Subject: FW: FW: Planning Consultation on: BN/57/20/DOC

Please upload onto Ocella the email trail below and the attachment from the **applicant** regarding discharge of condition application **BN/57/20/DOC** for the Lillies, Yapton Road, Barnham.

Outstanding comments

Condition 6 – Surface Water Drainage Design

SCALE	N.T.S @ A1	DATE	JULY 2019
DRAWN	SD	CHK	JGF
DRAWING NO.	17748-BARN-5-920	REV	D
TITLE	YAPTON ROAD BARNHAM

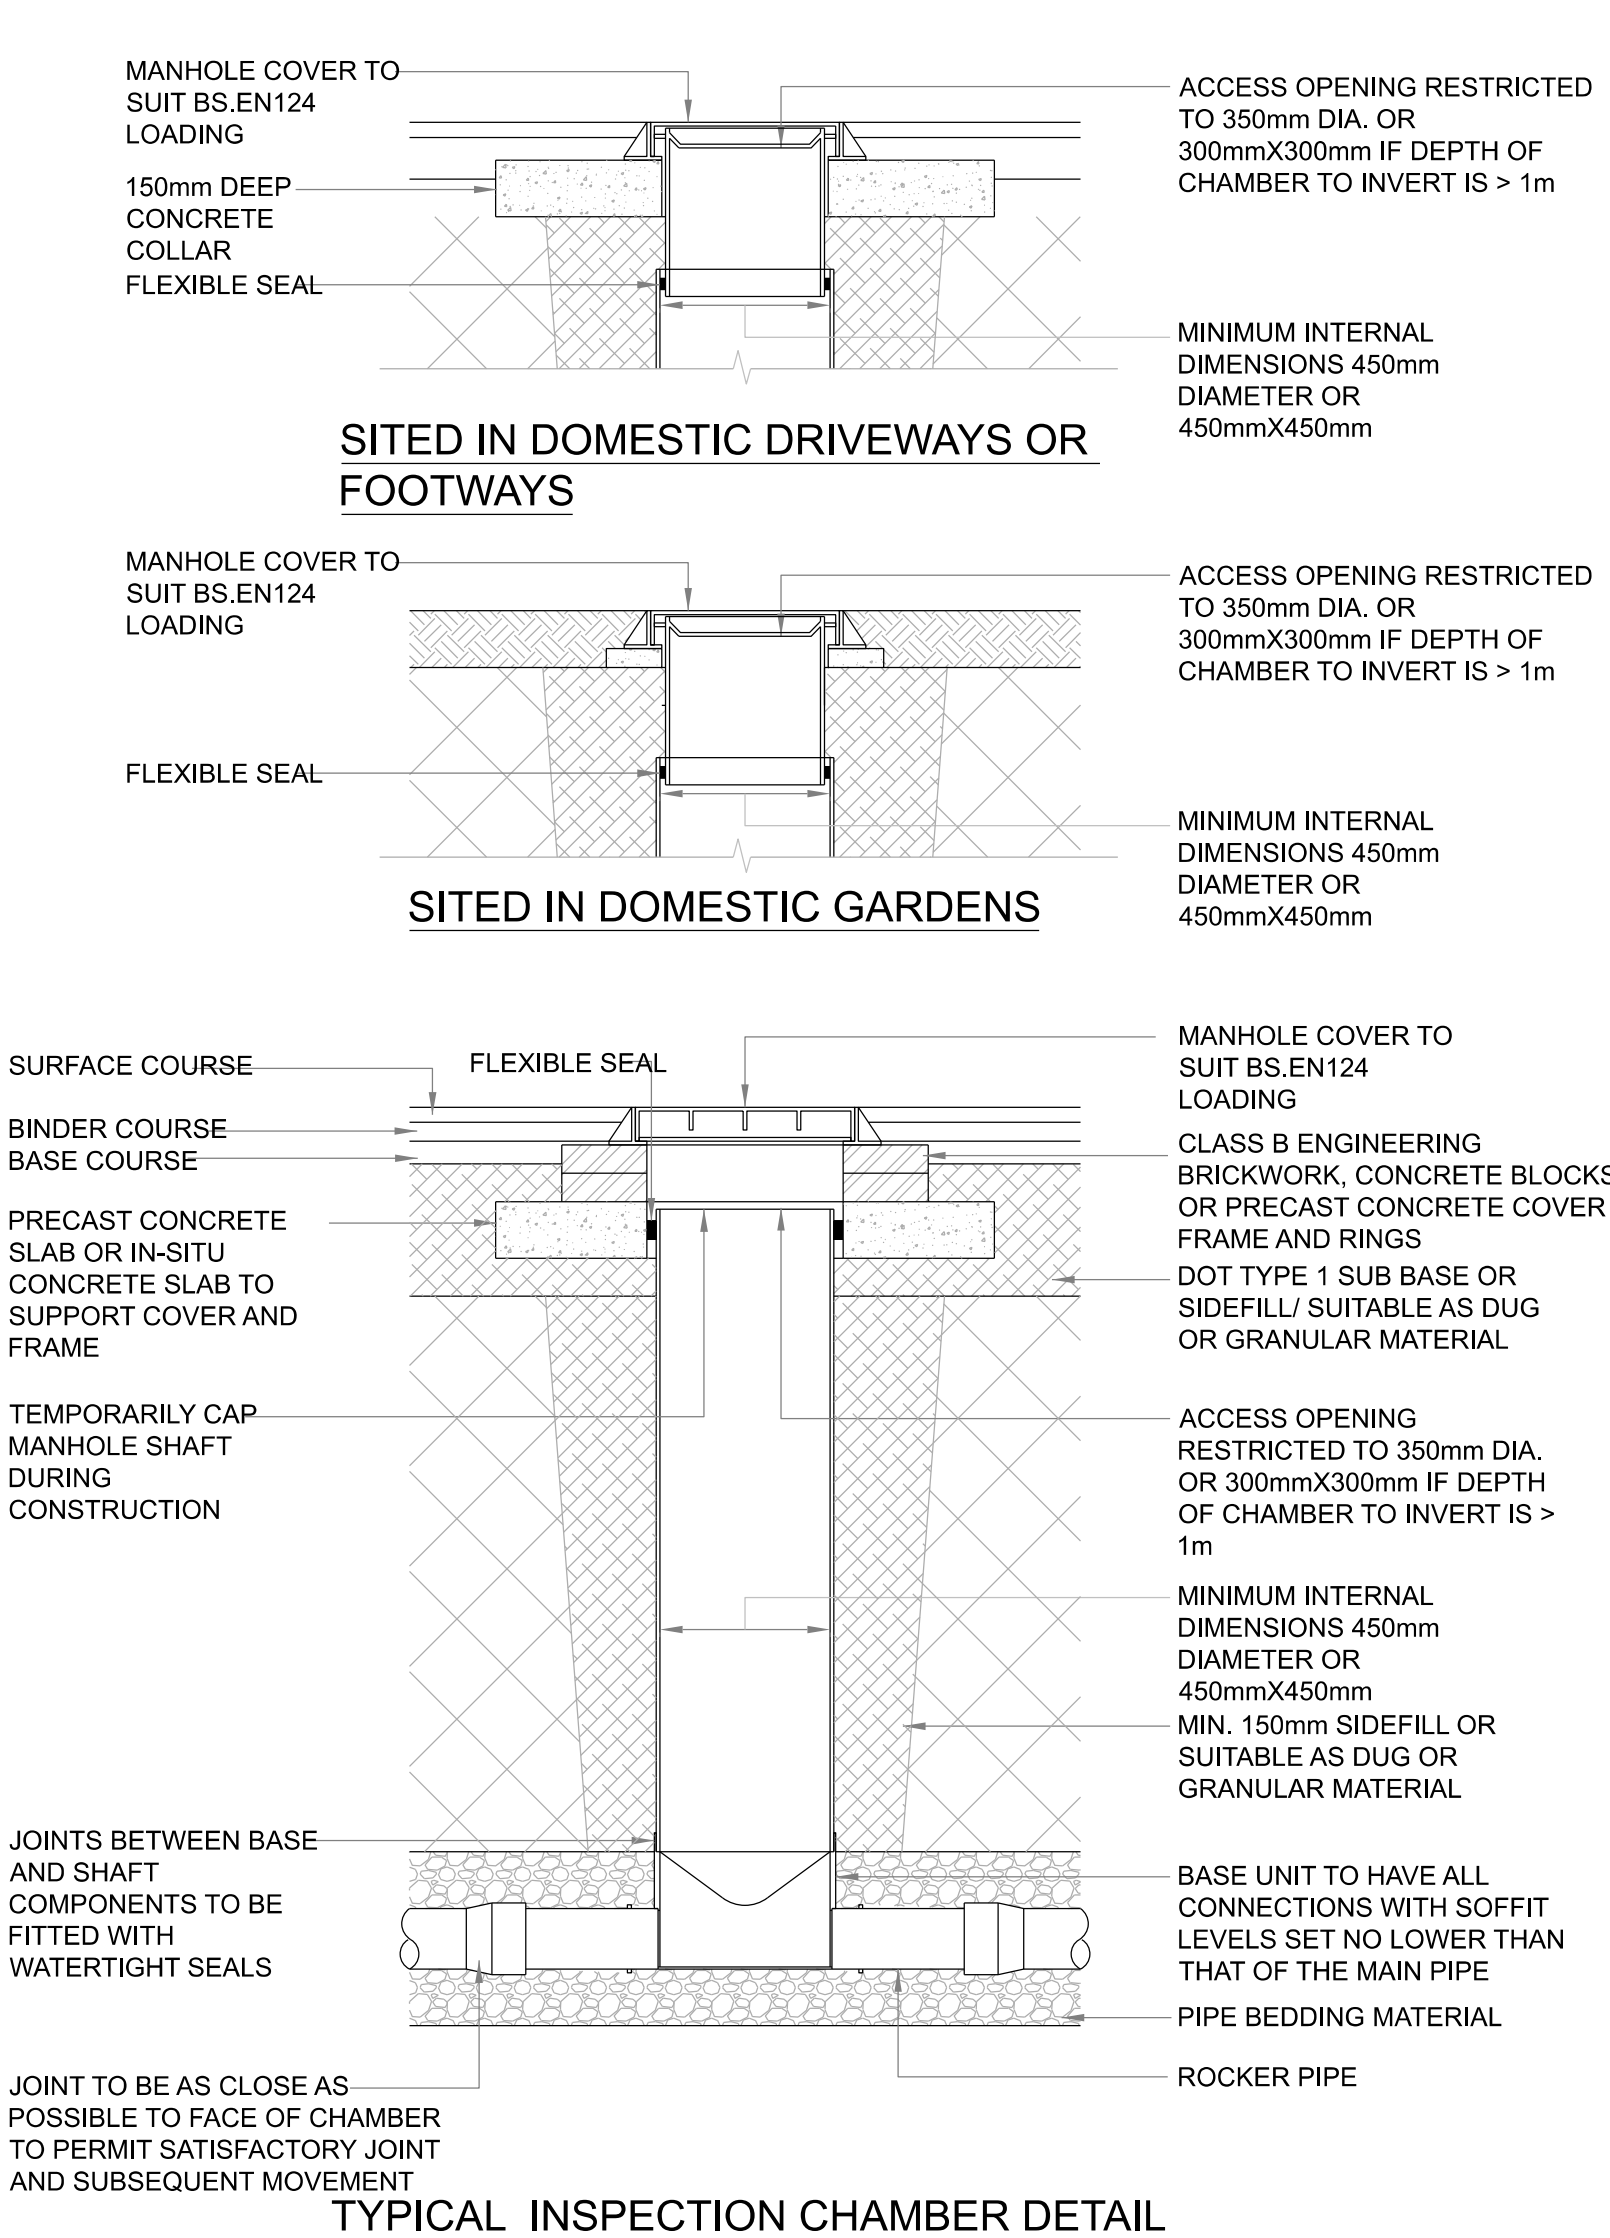
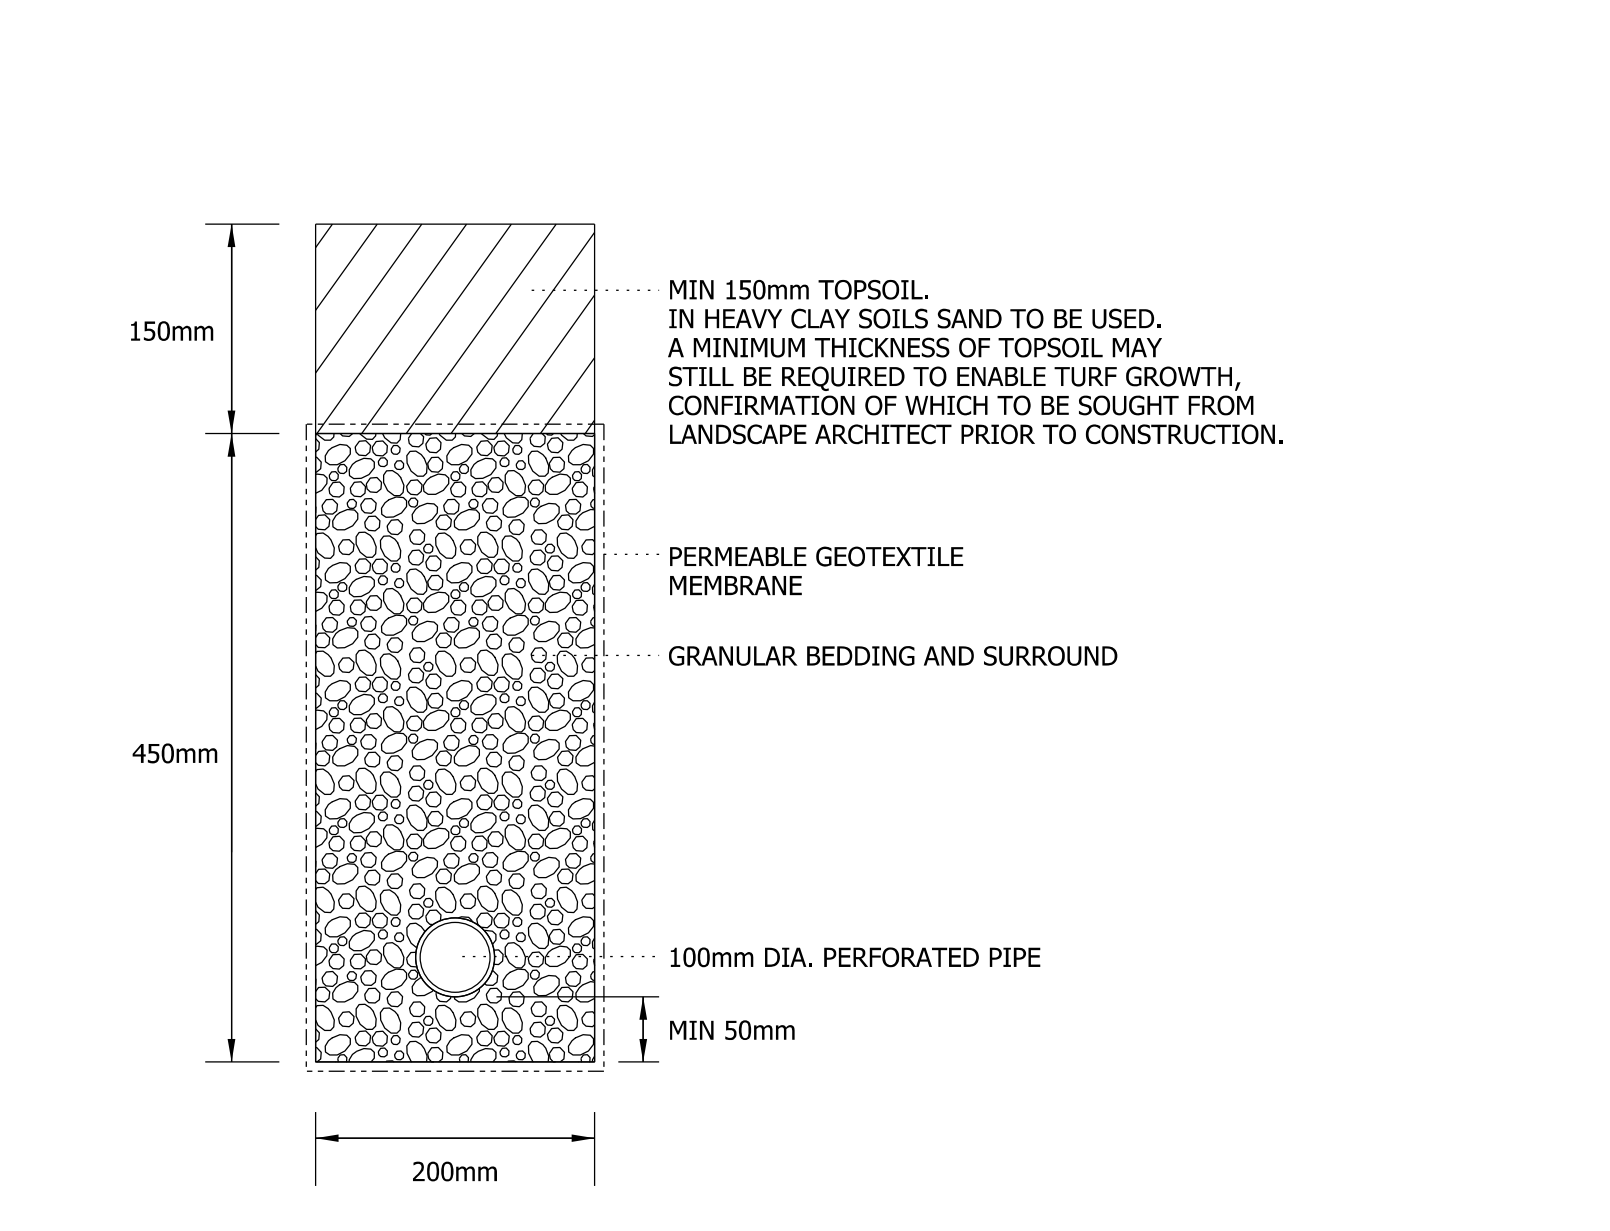
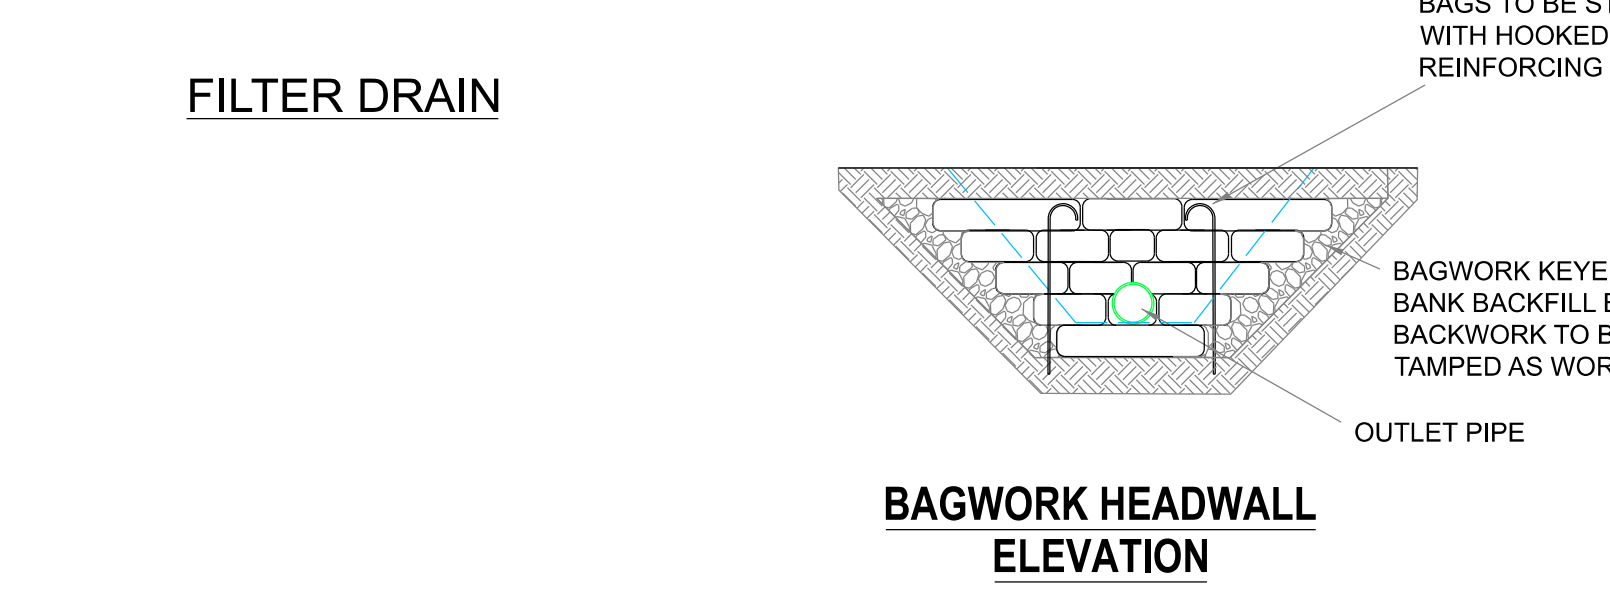
1. 7. (Condition 8- 2 and condition 10-2) This correspondence does not indicate prior approval of the proposed maintenance of the filter drain. Please add as an item for the management company to maintain from the downstream end. Quoted from that correspondence "Filter drain noted, however it needs to extend up to and including the rear of plot 12. Specify a 100mm pipe as opposed to 50mm. Rodding eye or manhole access required at head of run. Simple concrete bag headwall to be in accordance with the enclosed detail." These are the words of the Arun DC Drainage Engineer.

2. I do not believe it is realistic to expect adjacent homeowners to maintain the filter drain, access to this will be from the ditch, i.e. a communal area. Please reconsider. *The filter drain came at the suggestion of Paul Cann. There is rodding access at the opposite end to the ditch. It is entirely commonplace for filter drains in gardens to protect from water logged gardens. We are not arguing about them being proposed, but have asked that maintenance responsibility is reconsidered given the main point of access. Awaited. See attached correspondence from Paul Cann – Item 38. This item is closed.*

This correspondence does not indicate prior approval of the proposed maintenance of the filter drain. Please add as an item for the management company to maintain from the downstream end.

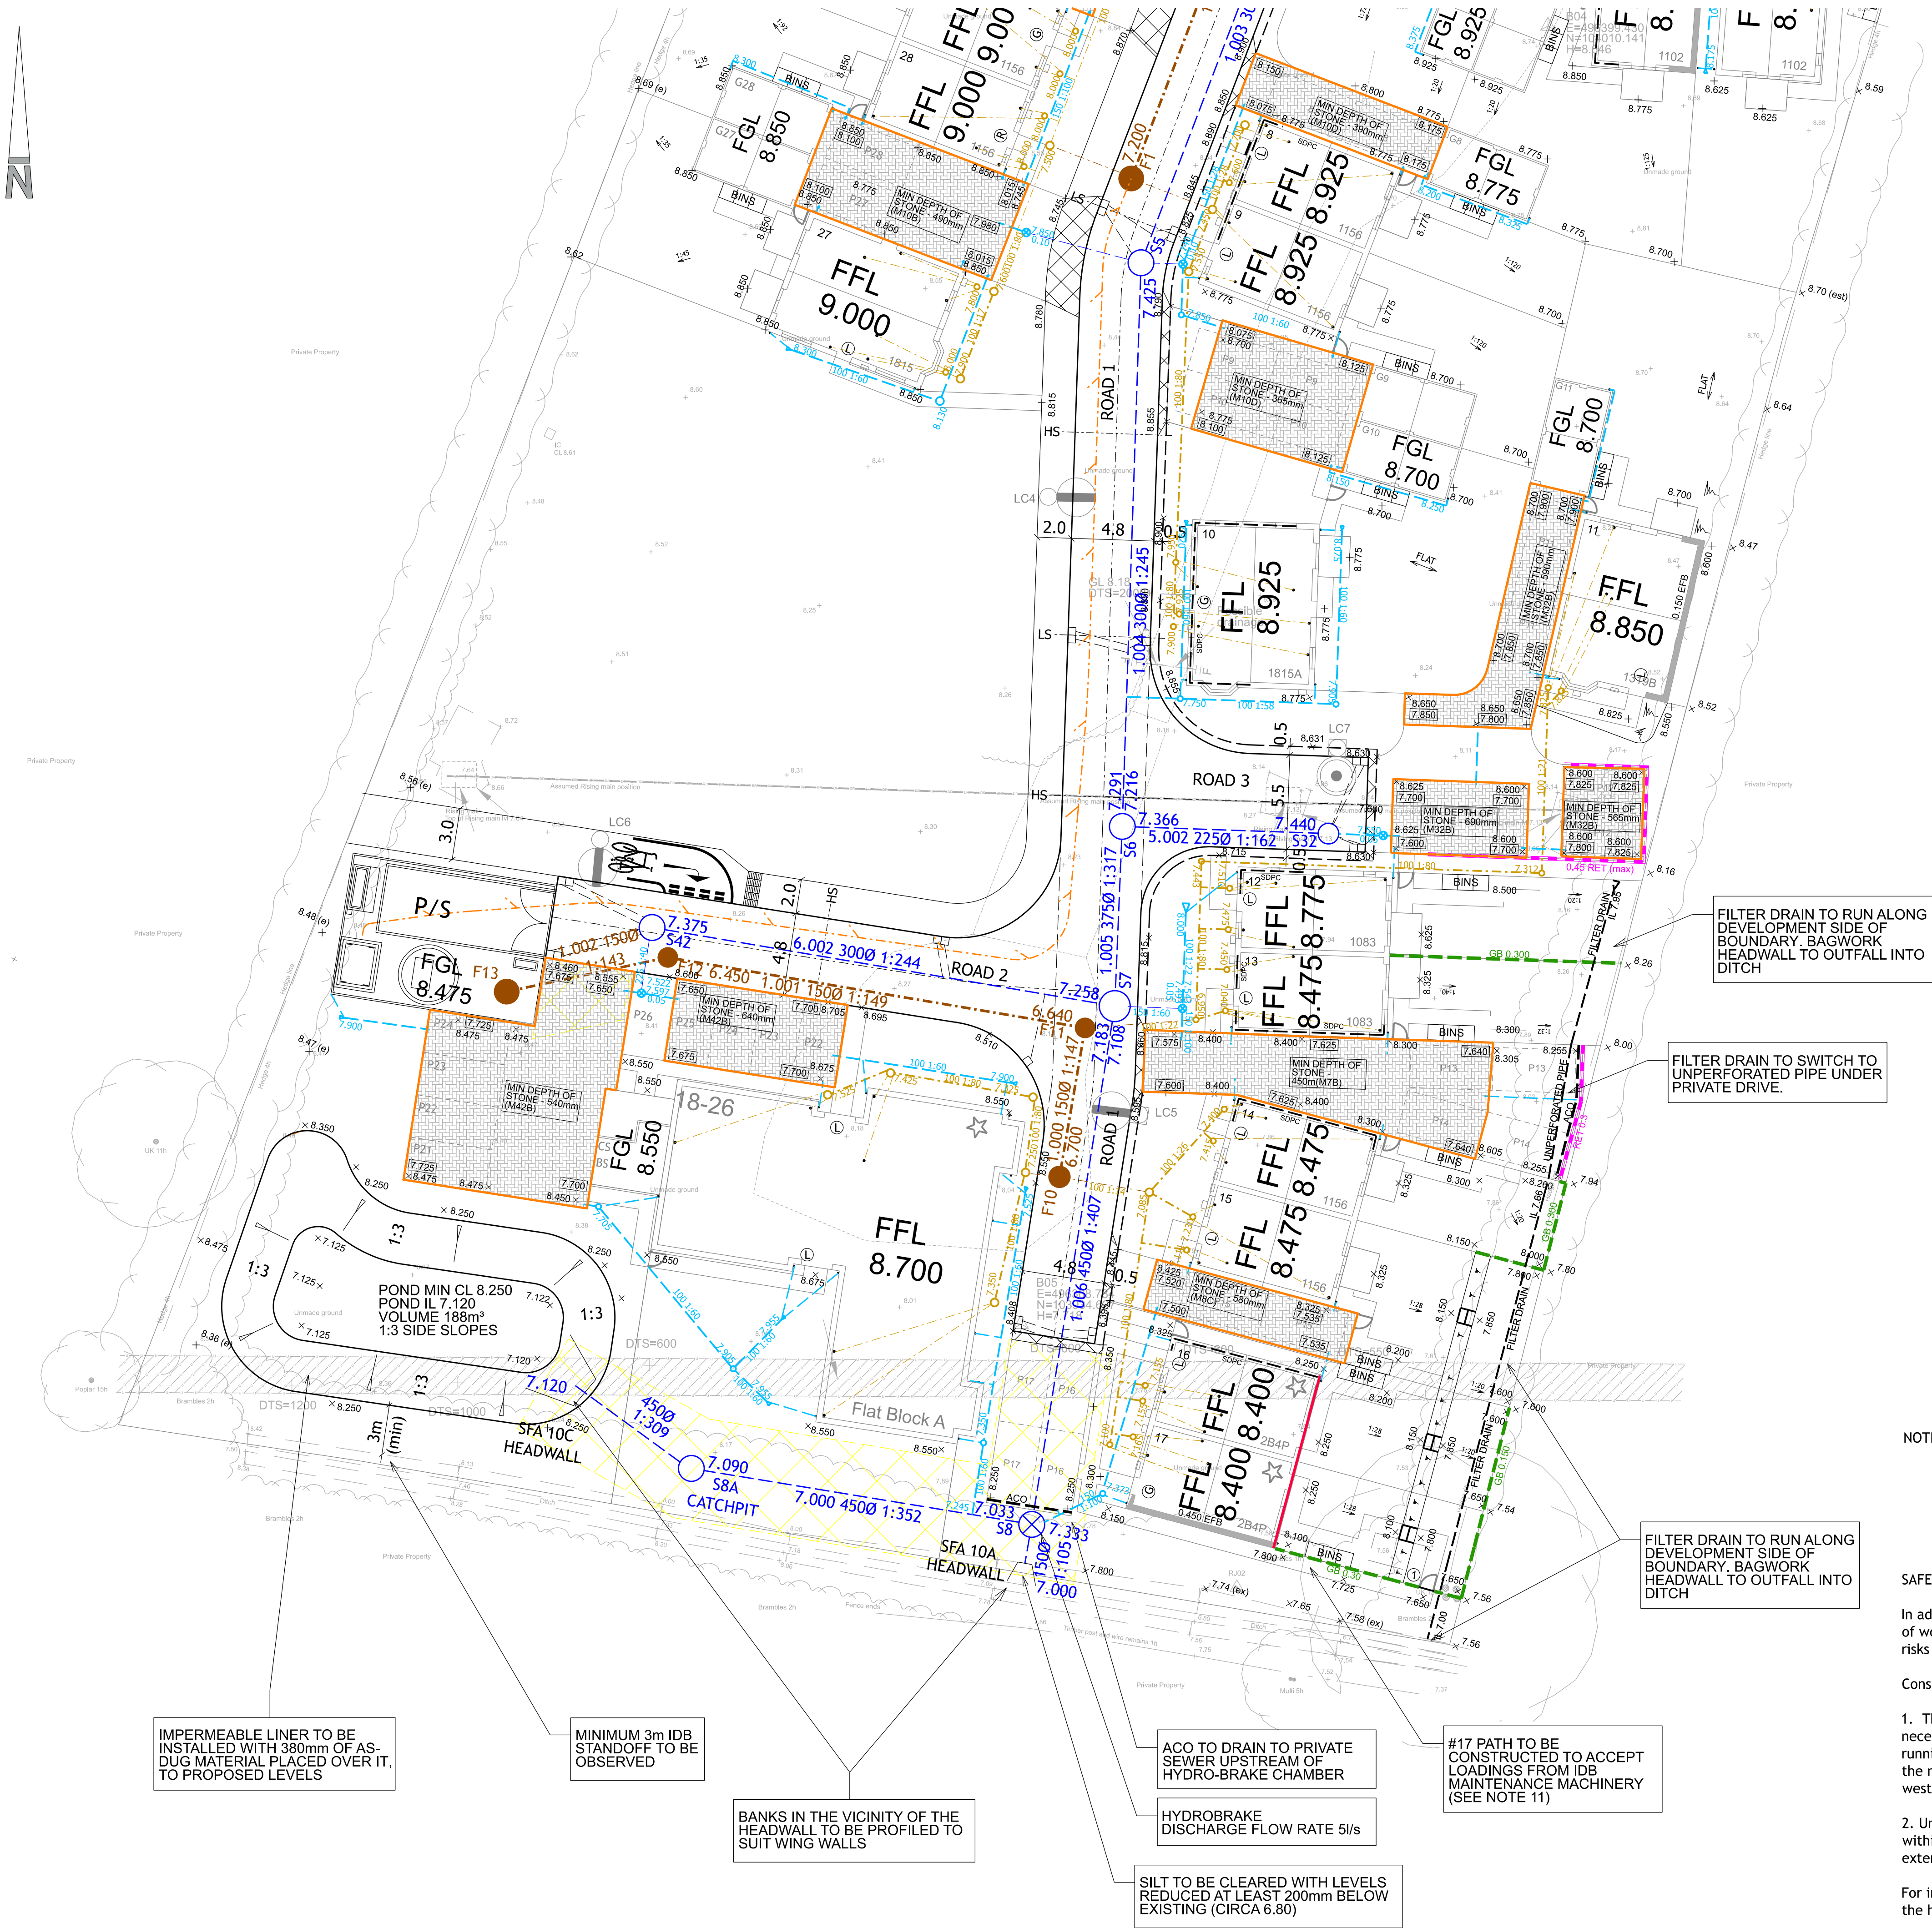
4. (Condition 6- 4) Please specify on plan stone depths on secondary permeable paving areas for 3b and 3d. Refer to the drawings. The finished level is shown as a spot level and the level next to it in a box is the formation level. See extract from key on drawing 17748-BARN-5-600

Invert level of car park node 3b shown to be 8.053 in calculations, this does not tally with plans. Please update to ensure consistency.

Please specify on plan stone depths on secondary permeable paving areas for 3b and 3d.
